CITY OF ALBUQUERQUE

July 10, 2014

**Re: Garcias Kitchen Food Prep & Catering
Grading and Drainage Plan
Engineer's Stamp Date: not stamped (J13/D096)**

GRADING AND DRAINAGE PLAN

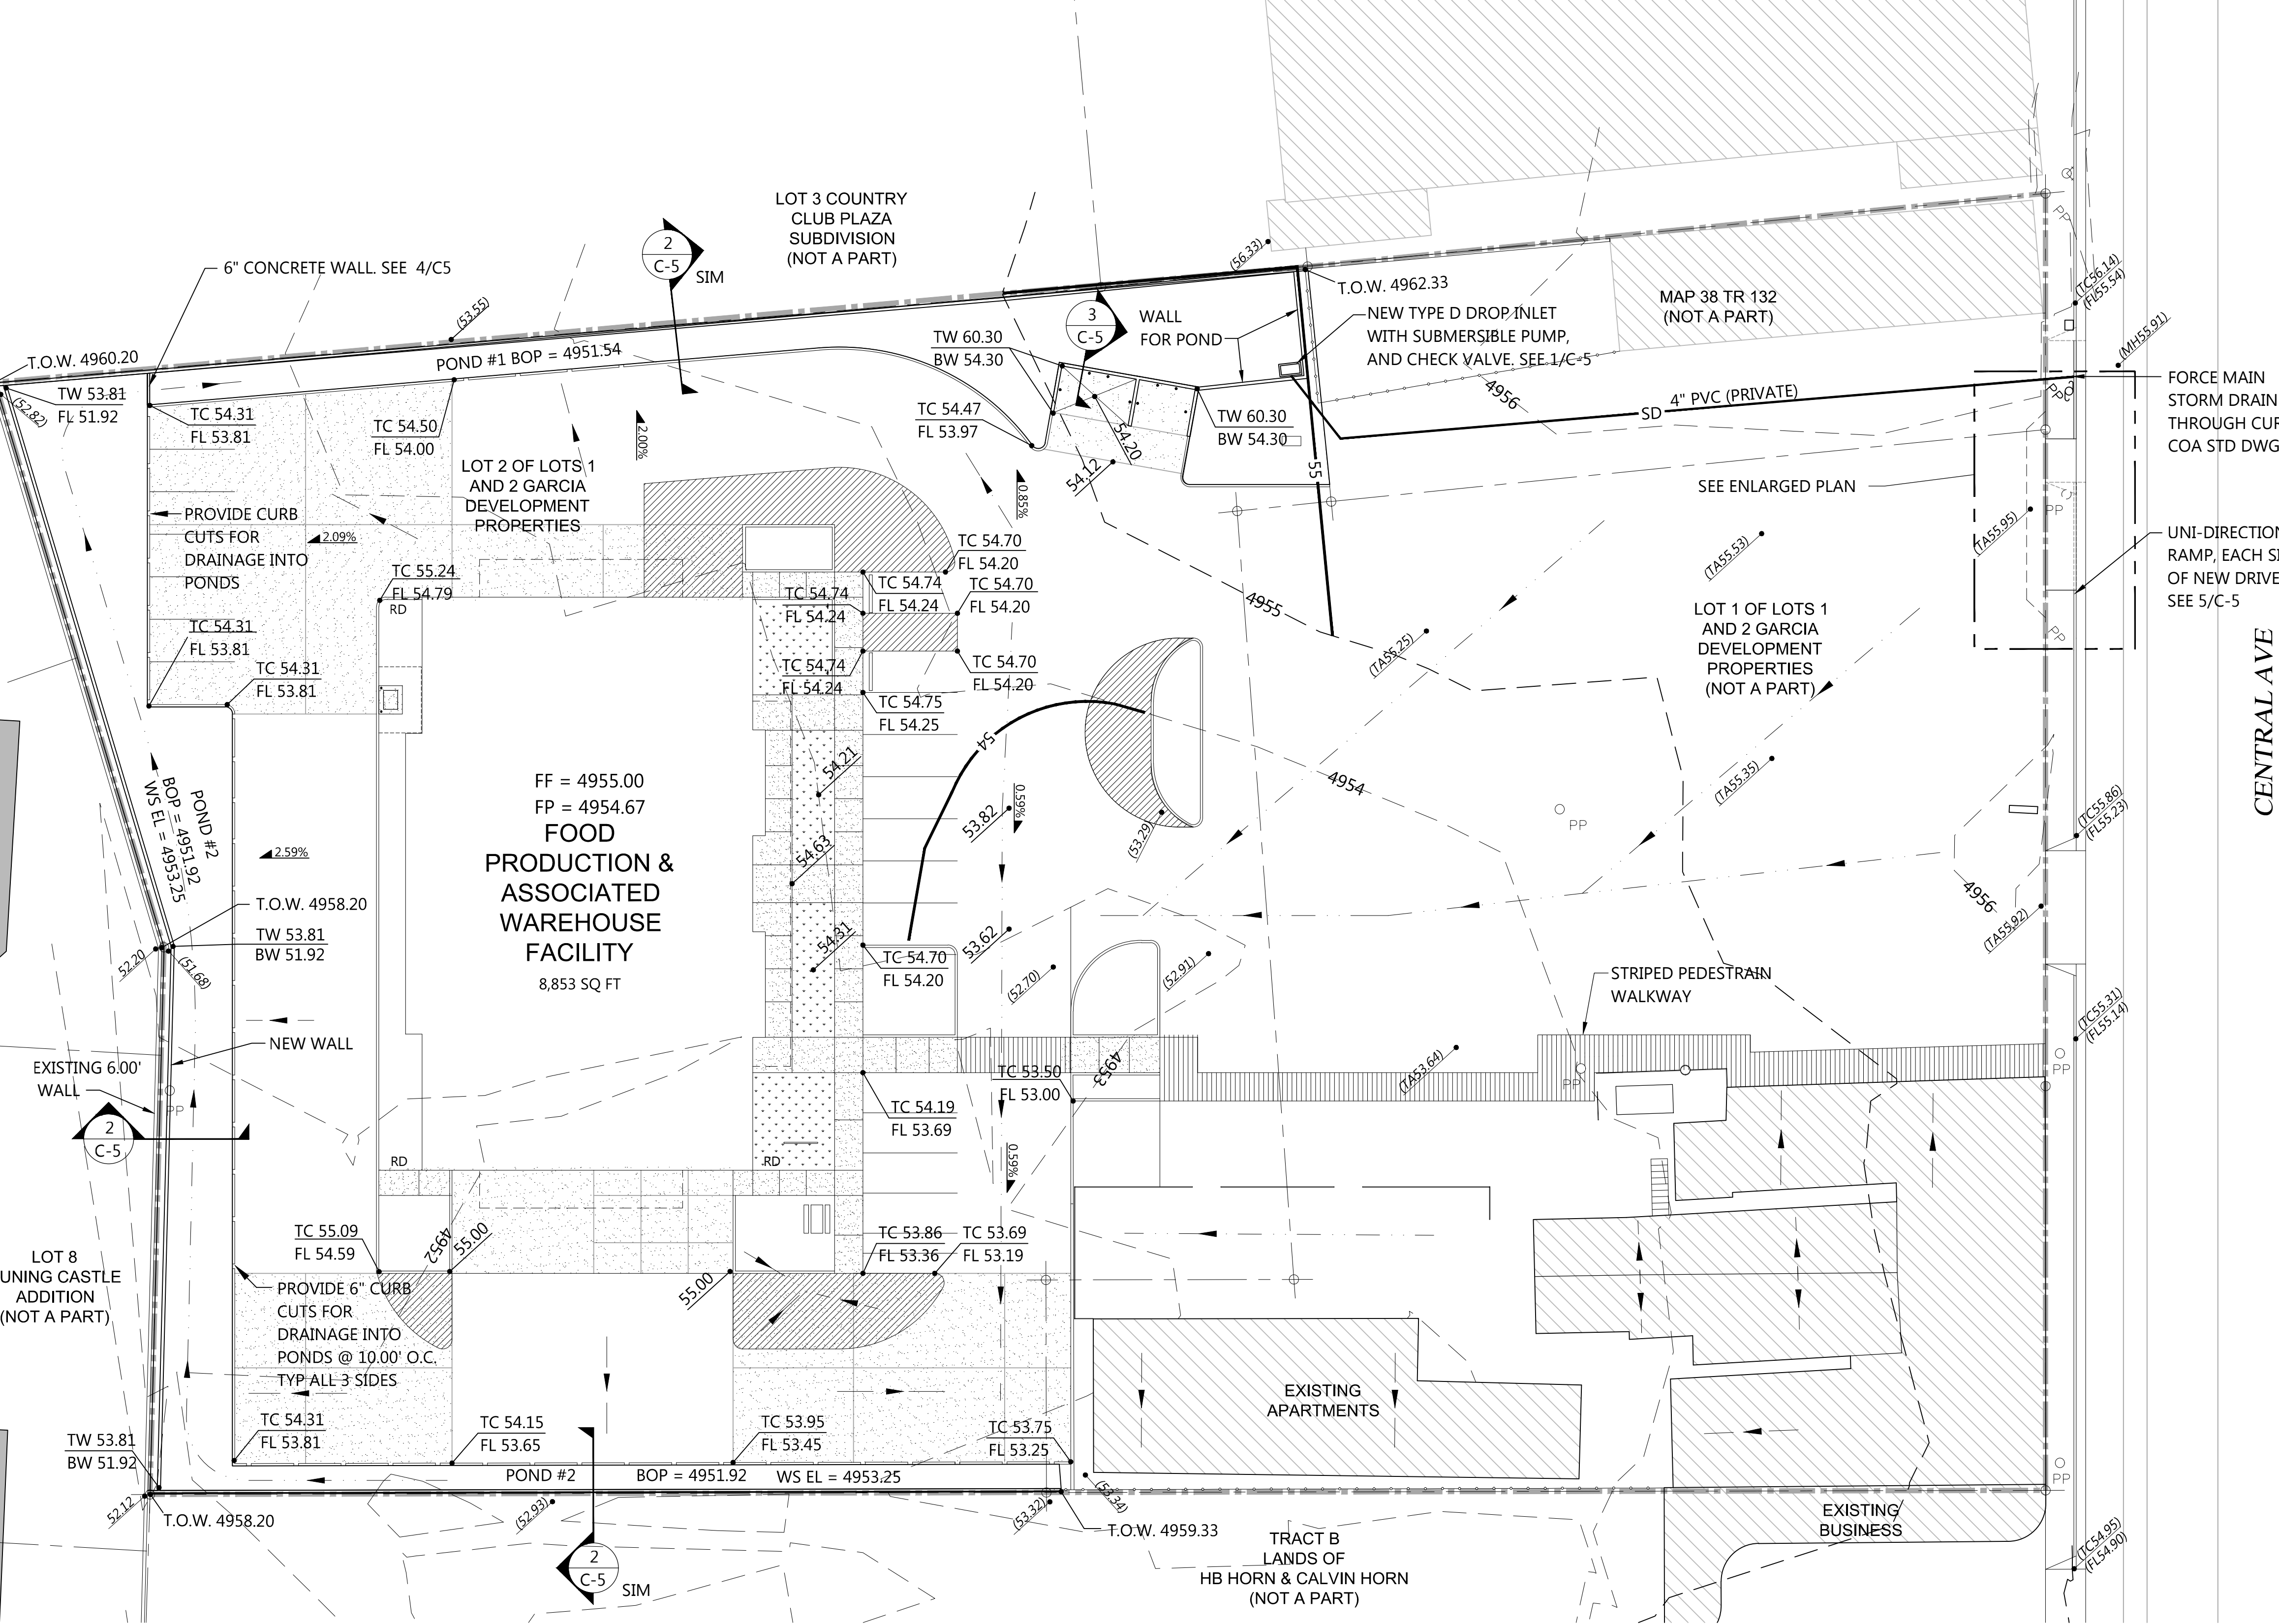
1. All plans and calculations need to be stamped by an engineer.
2. Onsite flows from the existing restaurant and apartments must be accounted for. The proposed curb south of these existing structures does not allow roof runoff from these structures to drain to Pond 2.

3. Roof runoff from the apartments appear to drain offsite to east and then reenter the property and drain to south west, along with some amount of offsite flows. LIDAR contours support this and so this onsite/offsite flows need to be accounted for. In addition, it appears that a wall is to be built along west property boundary. How will flows from apartments reenter?

4. Sections thru pond on East and West property boundaries need to be shown to indicate how flows will reenter, or how overflows will be contained on site.

5. It appears that Pond #2 Volume should be the total volume of both ponds #2 and #3 from the previous submittal. With a combined larger volume, the WSEL will be lower.

6. While a check valve is indicated on the plans, it is not clear where the check valve will be located. Indicate location of check valve. Also indicate what construction will be done thru Work Order and the CPN #.

PERFORMANCE CURVE

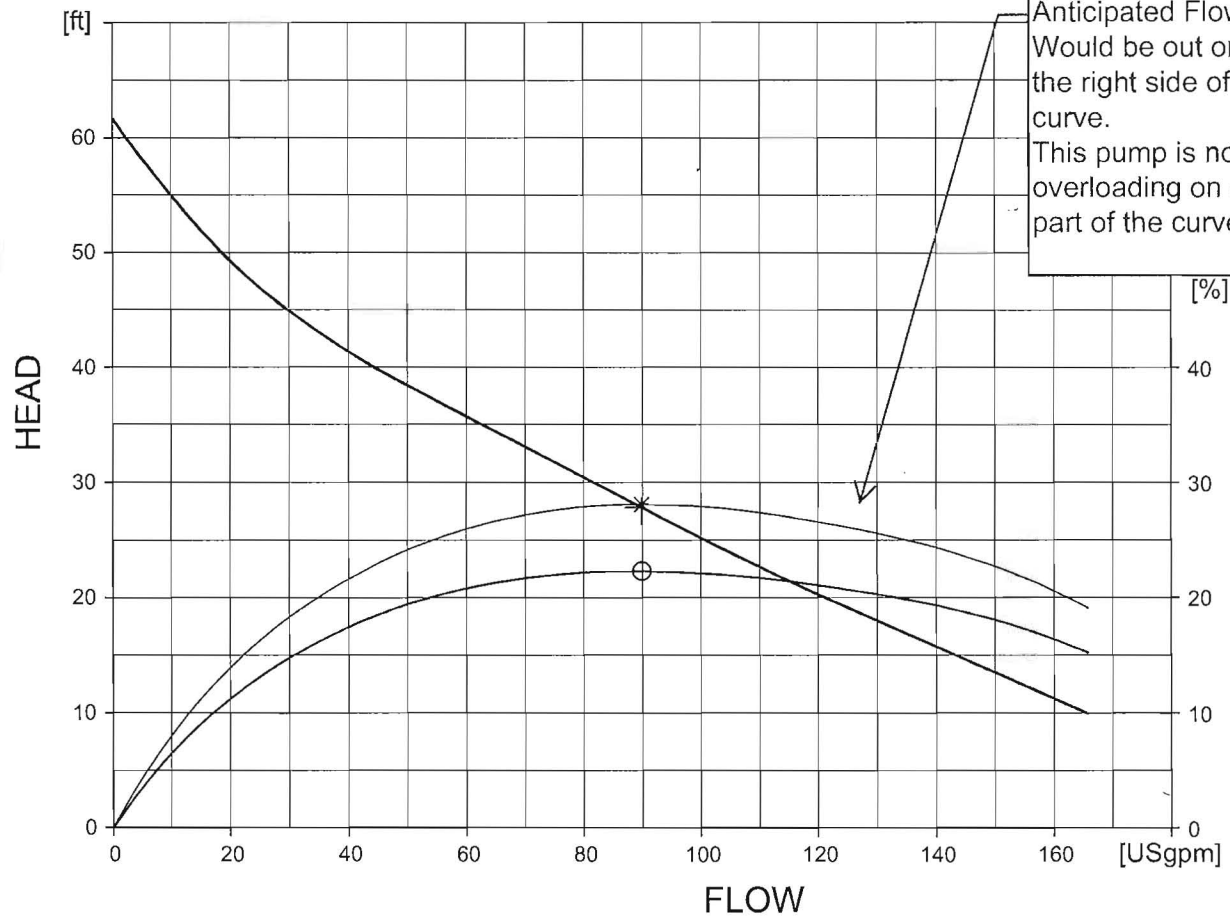
7. Details 1/C-5 and 3/C-5 show retaining walls that need to be designed, detailed, and dimensioned.
8. Pump cut sheets provided show general information but do not show where on the curve the pump will operate (which is typically shown on a system curve), nor are there supporting calculations. Please provide.
